<p>This consultation response uses extracts of maps from <i>A66 Northern Trans-Pennine project – Routes for consultation General Arrangement drawings as reference points for comments relating to Cumbria only.</i></p>	<p>Project proposals</p>	<p>Comment</p>
<p>General comments:</p> <ol style="list-style-type: none"> 1. Many opportunities have been missed for providing additional linking public rights of way for pedestrian / pedal-cycle / horse along the whole of the proposed route. 2. Where there are no adjacent minor roads which peds / cyclists / horse riders may use as convenient alternative to the A66 such provision should be made as part of the A66NTP project. 3. Some of the proposals relating to public paths are outside of the red-line. Does this mean that they will not be covered by the DCO and will have to be done by CCC? 		
<p>Statutory Consultation legend (p5)</p> 		<p>Change notation that gives much clearer indications of sections of routes that are the extinguished and created as part of diversion proposals.</p>

GW 01.11.2021

Drawing Title:
**Classification of Roads Plan
Regulation 5(2)(o)
Sheet 1 of 2**

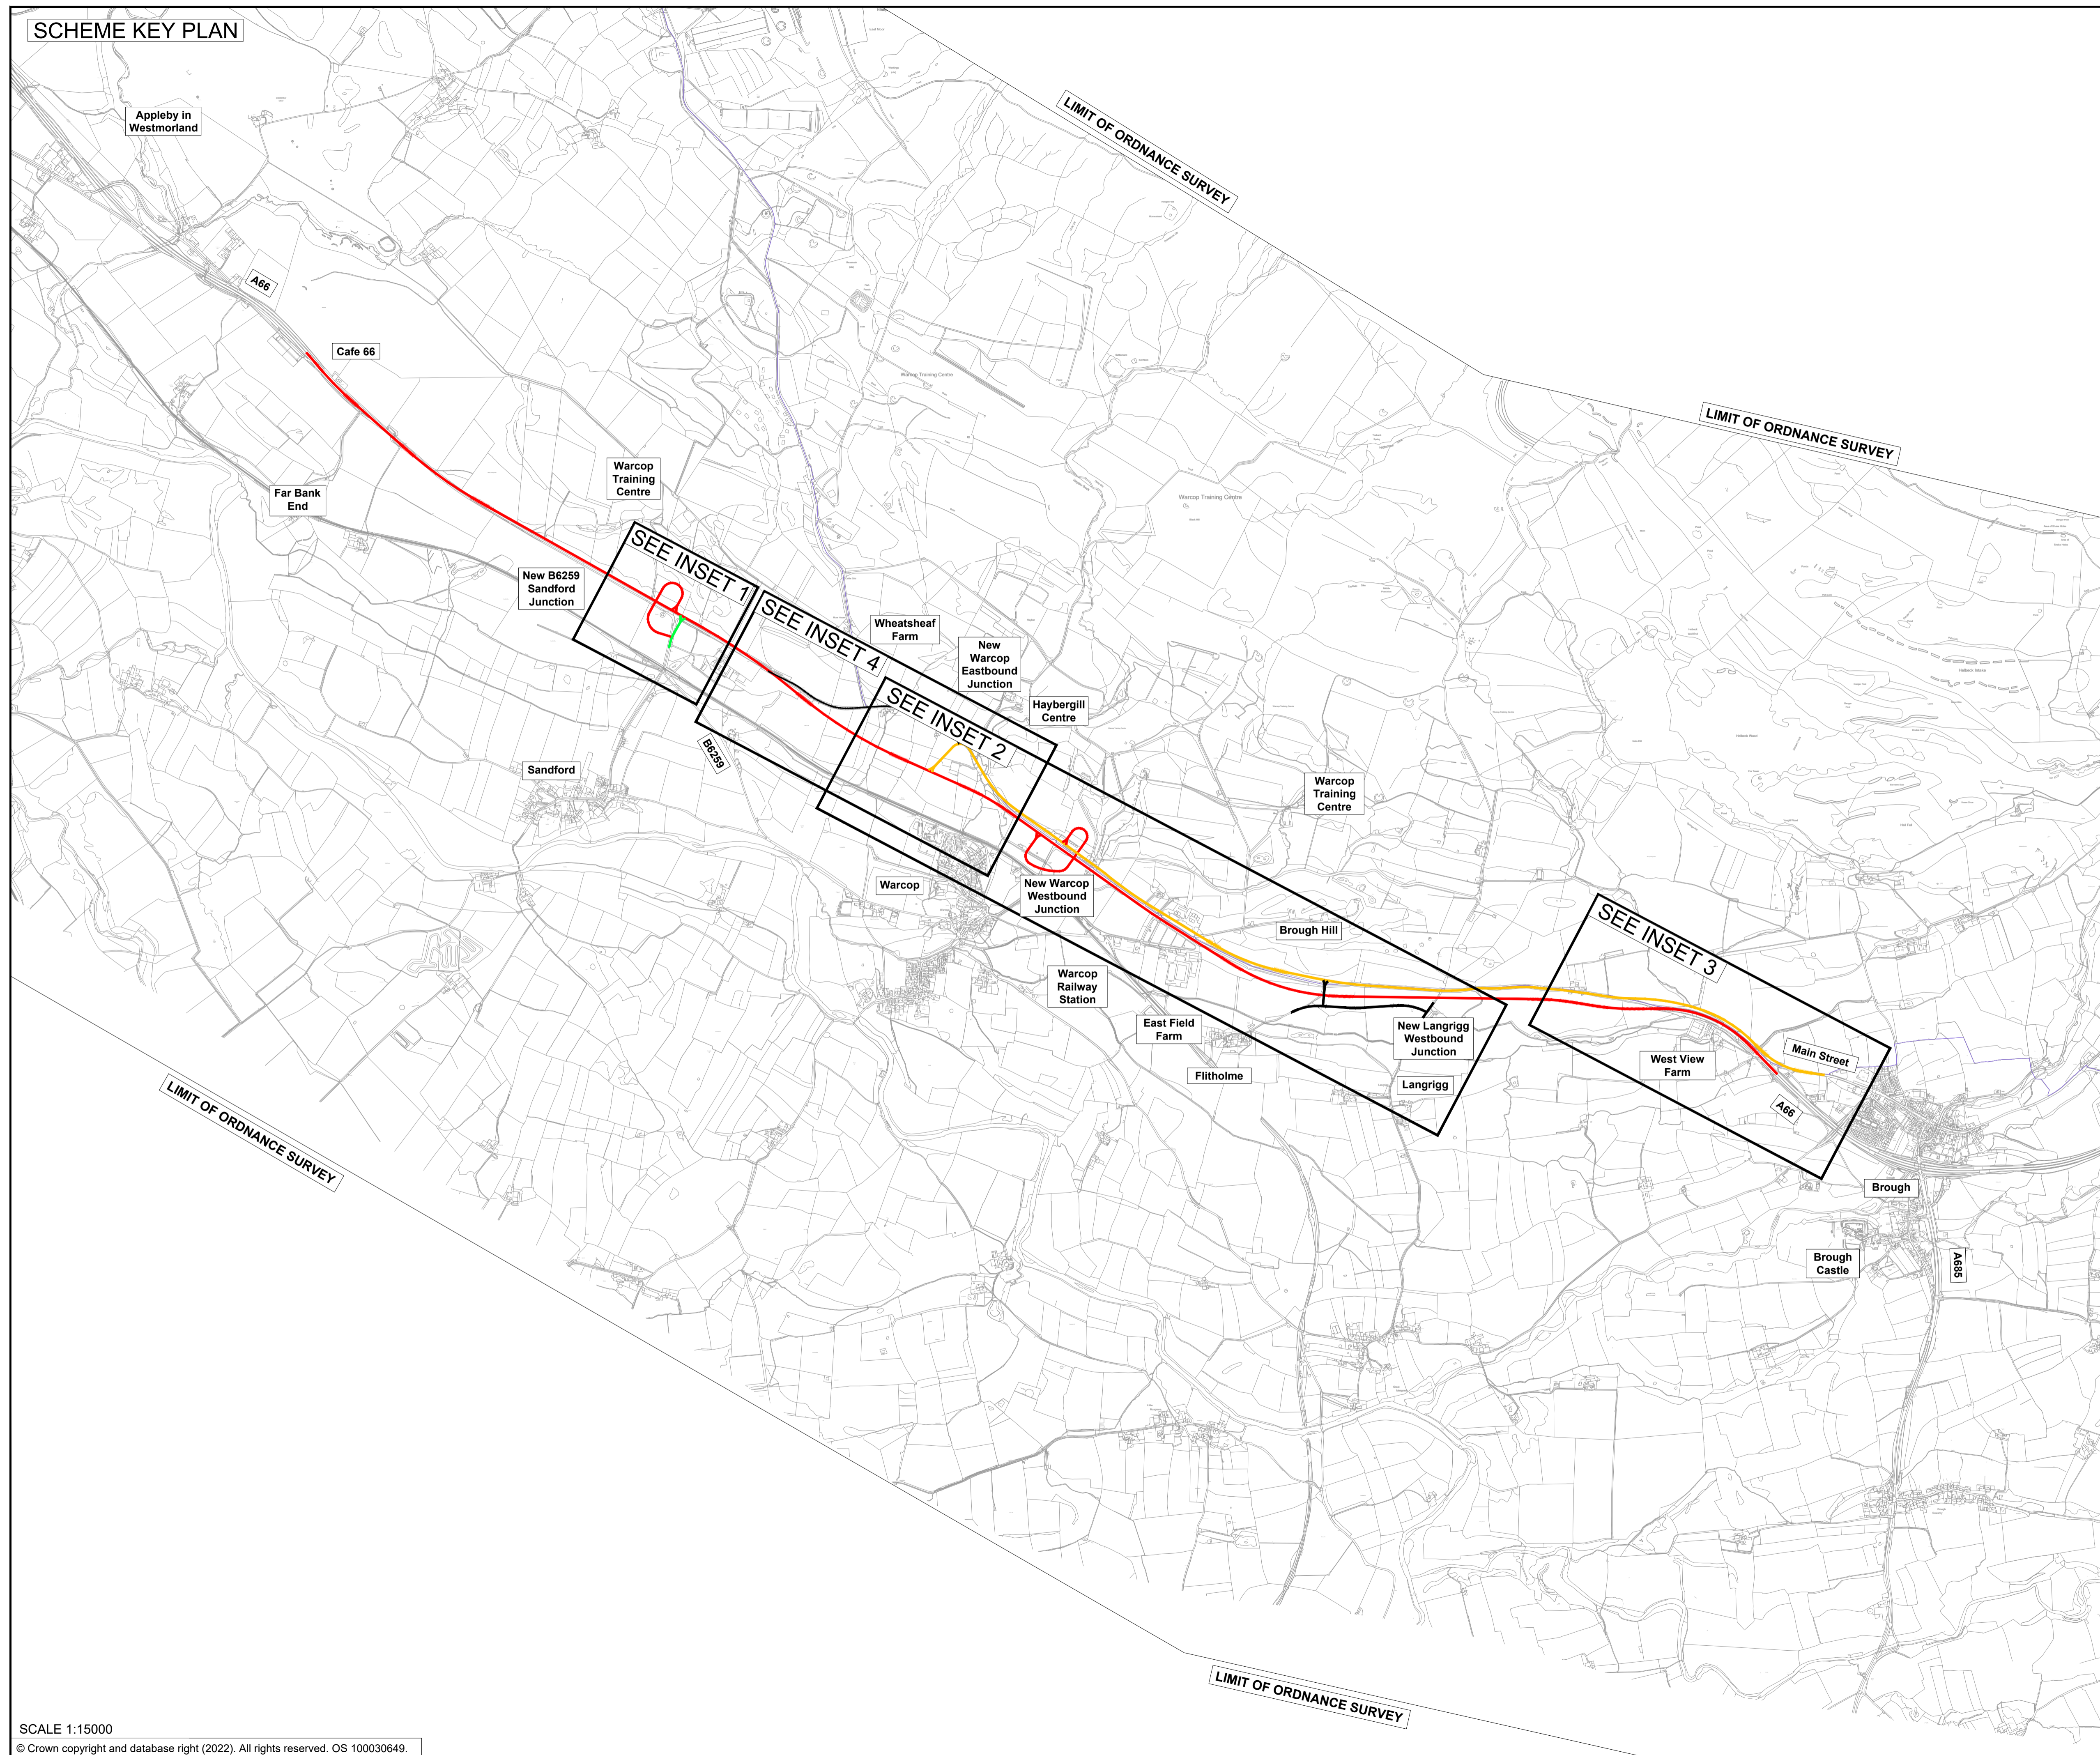
Project proposals	Comments
<p>Temple Sowerby to Appleby (p13) – Temple Sowerby link.</p> 	<p>BW 336007 to be diverted via underpass.</p>	<p>Section of proposed diversion route is superimposed on diverted Priest Lane (U3119). Is this a mapping error? Or is a definitive FP to be created alongside the U3119? Or is the path alongside the U3119 to be part of the U3119 (a footway)?</p>
<p>Temple Sowerby to Appleby (p15) – Temple Sowerby link.</p> 	<p>BW 336018 to be diverted around drainage pond to new point of termination on road C3030 (and over A66 via road bridge).</p>	<p>Section of proposed diversion route is superimposed on diverted C3030. Is this a mapping error? Or is a definitive FP to be created alongside the C3030? Or is the path alongside the C3030 to be part of the C3030 (a footway)?</p>
<p>Temple Sowerby to Appleby (p15) – Temple Sowerby link.</p> 	<p>FPs 336013 & 336017 to be diverted via a common bridge.</p>	<p>Consultation material states that bridge is for 'farm traffic, walkers, cyclists & horse riders' ... but the paths being diverted are footpaths only! The diverted paths and connecting paths (outside of the red-line) should be upgraded to bridleway in order that cycle and horse can avoid the proposed Kirkby Thore junction.</p> <p>Create new BW on this farm access track.</p>

Project proposals	Comments
<p>Temple Sowerby to Appleby (pp17 & 18).</p> 	<p>FP 341017 at Powis House to be diverted to new termination at C3063 (Longmarton Road), over new Longmarton Road bridge and to old A66.</p>	<p>Section of proposed diversion route is superimposed on diverted C3063 and old A66. Is this a mapping error? Or is a definitive FP to be created alongside the C3063? Or is the path alongside the C3063 to be part of the C3603 (a footway)?</p>
<p>Temple Sowerby to Appleby (p 18 & 20).</p>	<p>Consultation mapping not totally clear here. It seems that FP 317016 is effectively being extinguished and ped'n traffic is to be directed along via new underpass to slightly diverted BW 317012 and new termination point with BW 341001.</p>	<p>Mapping requires clarification.</p>

<p>Project proposals</p>	<p>Comments</p>
<p>Temple Sowerby to Appleby (p20).</p> 	<p>FP 317004 to be diverted to new termination point with BW 341001 via new underpass.</p>	<p>No comments.</p>
<p>Appleby to Brough (p24)</p>	<p>FP 372028 to be diverted via diverted U-Road and New Hall Farm Underpass.</p>	<p>Clarification required over diversion / extinguishment of FP 372028, and diversion of U 3261. Diverted U 3261 must remain public vehicular.</p>
